AVIVA Investors Ltd

Victoria Road Retail Park

Date: 19th November 2014

Ref: N02-AW- Post Application Response

DRAWING NUMBER:	130938B/AT/01	REVISION:	
-----------------	---------------	-----------	--

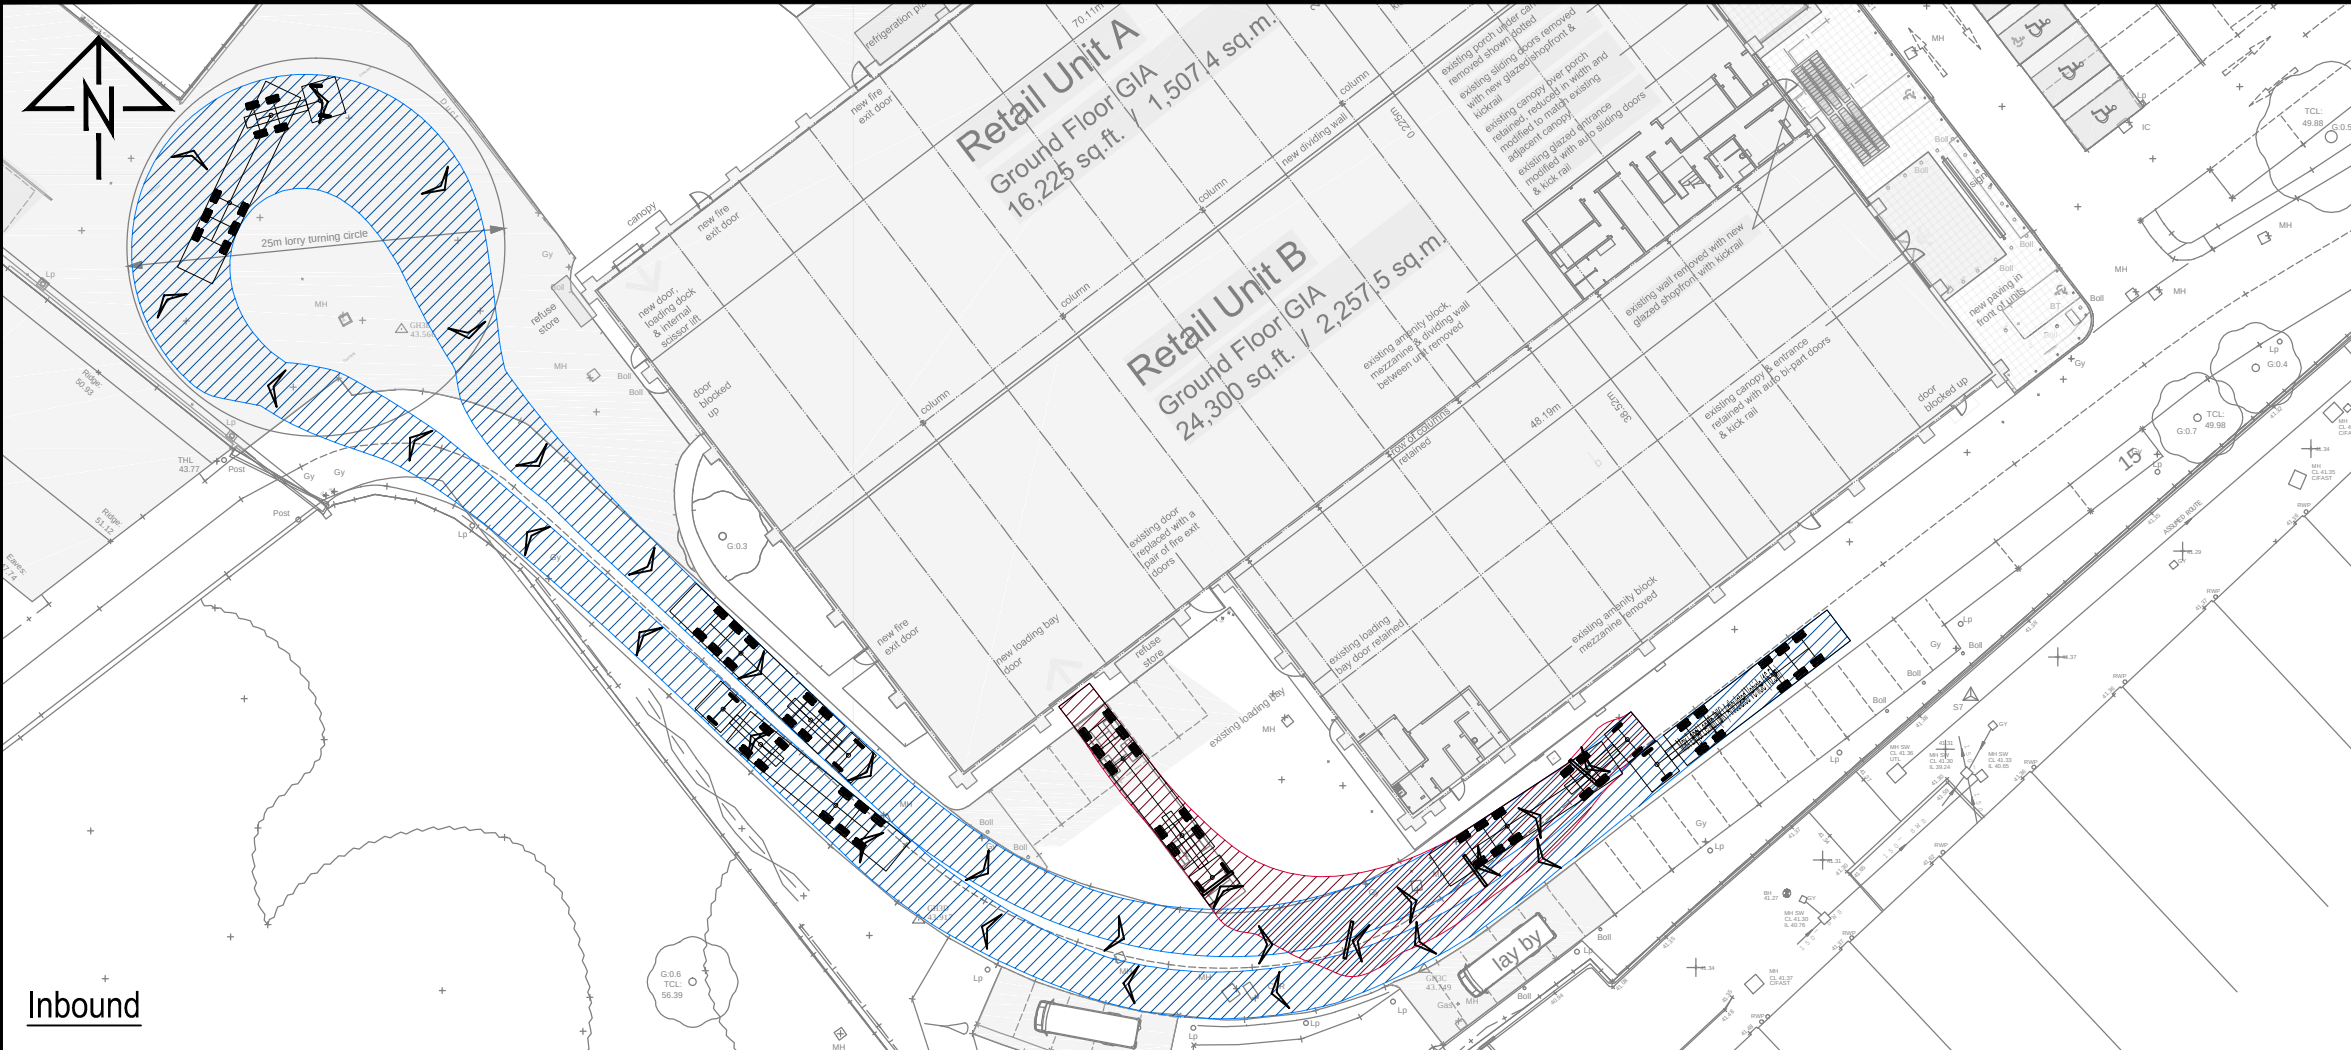
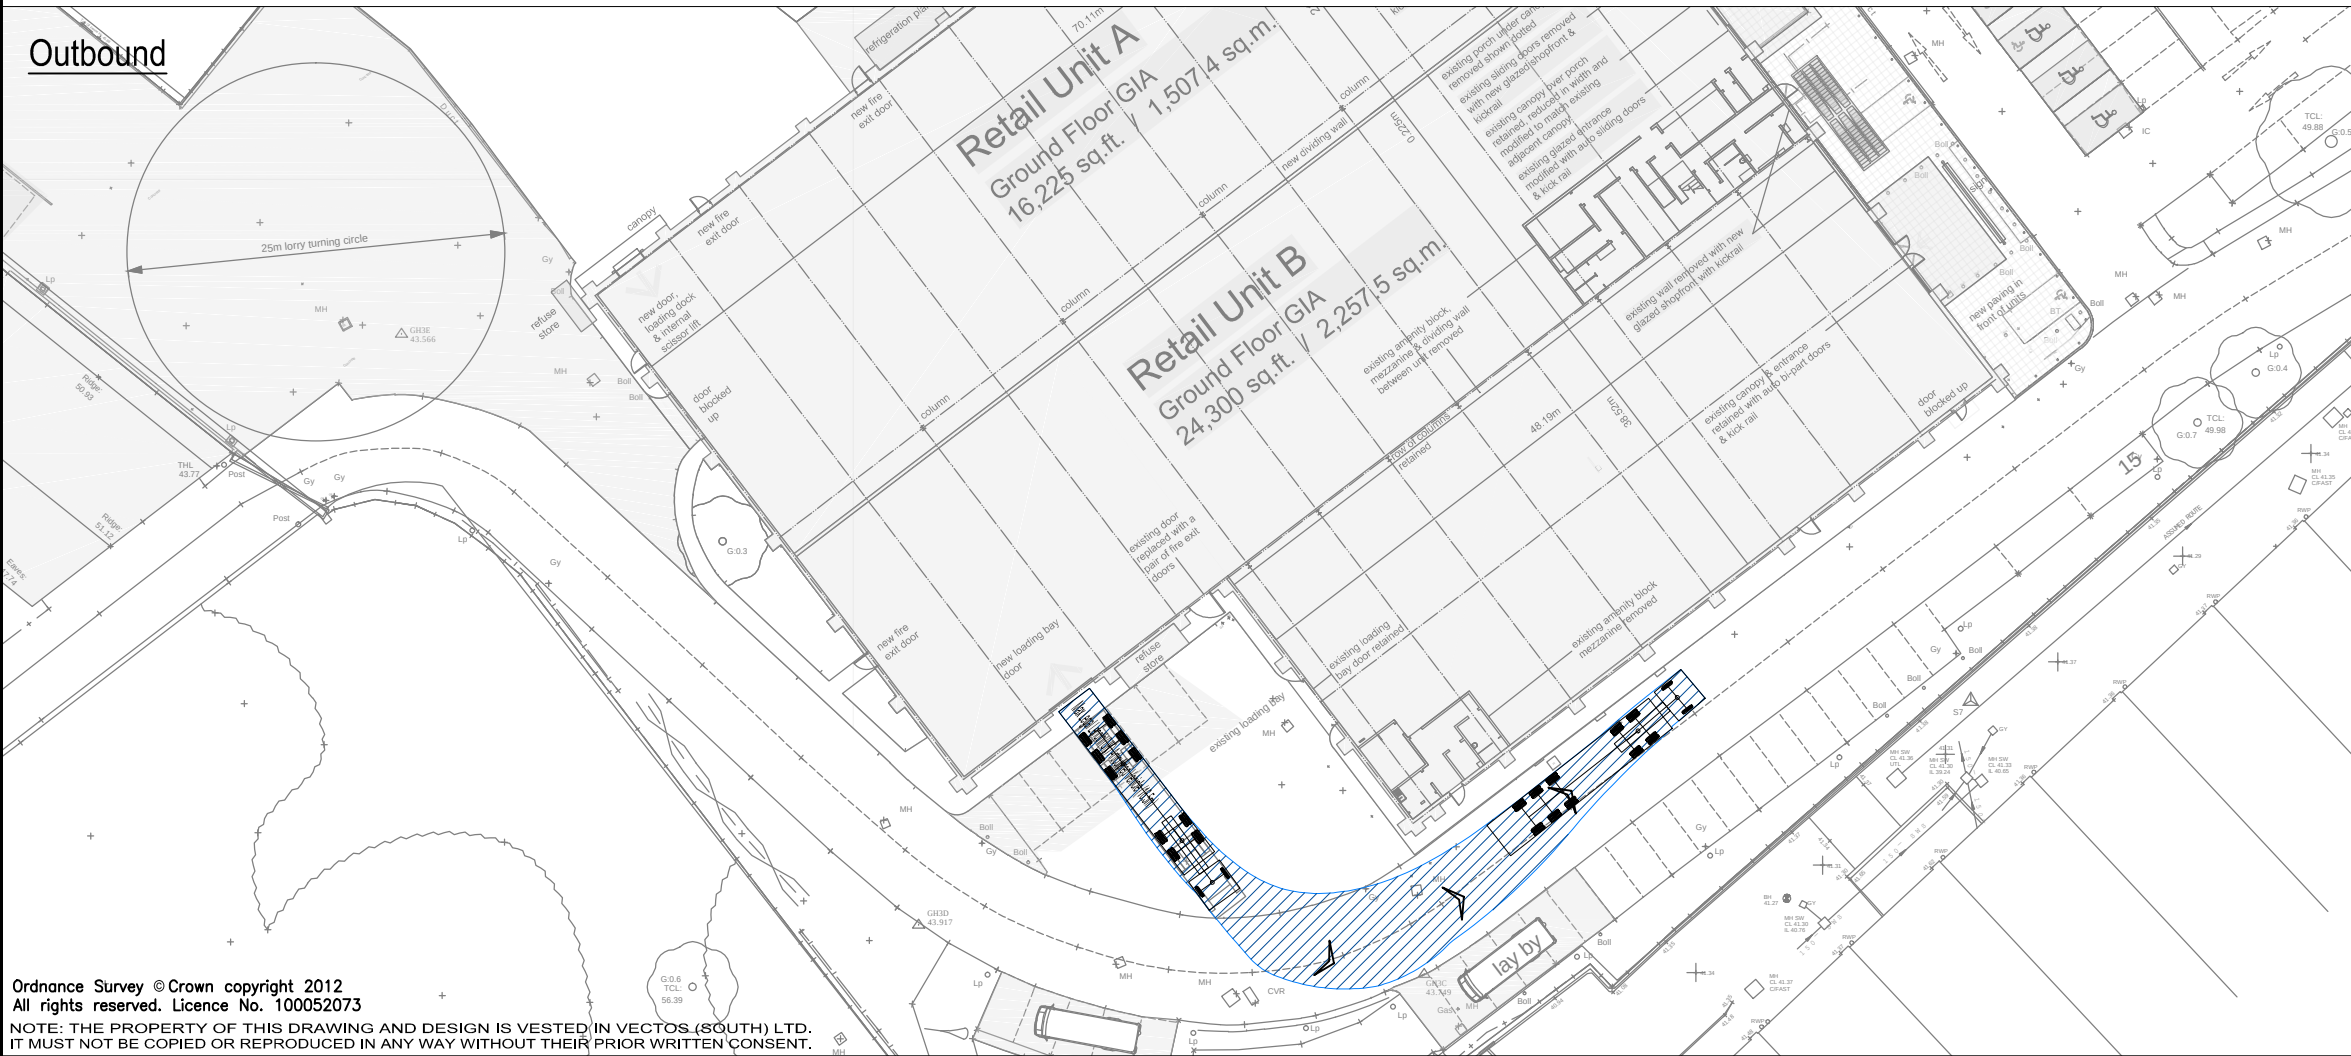
38. It should be noted that swept path plots using AutoTrack are already considered to include a margin of error. In line with comments received from the LBH, a further 300mm margin of error has been applied to the submitted vehicle track plots. The revised drawings showing a 16.5m articulated vehicle entering and exiting both Units A and B can be viewed at **Drawing 130938A_AT_B01**.
39. The revised track plots show that servicing of the units can still be undertaken safely with the inclusion of the margin of error.
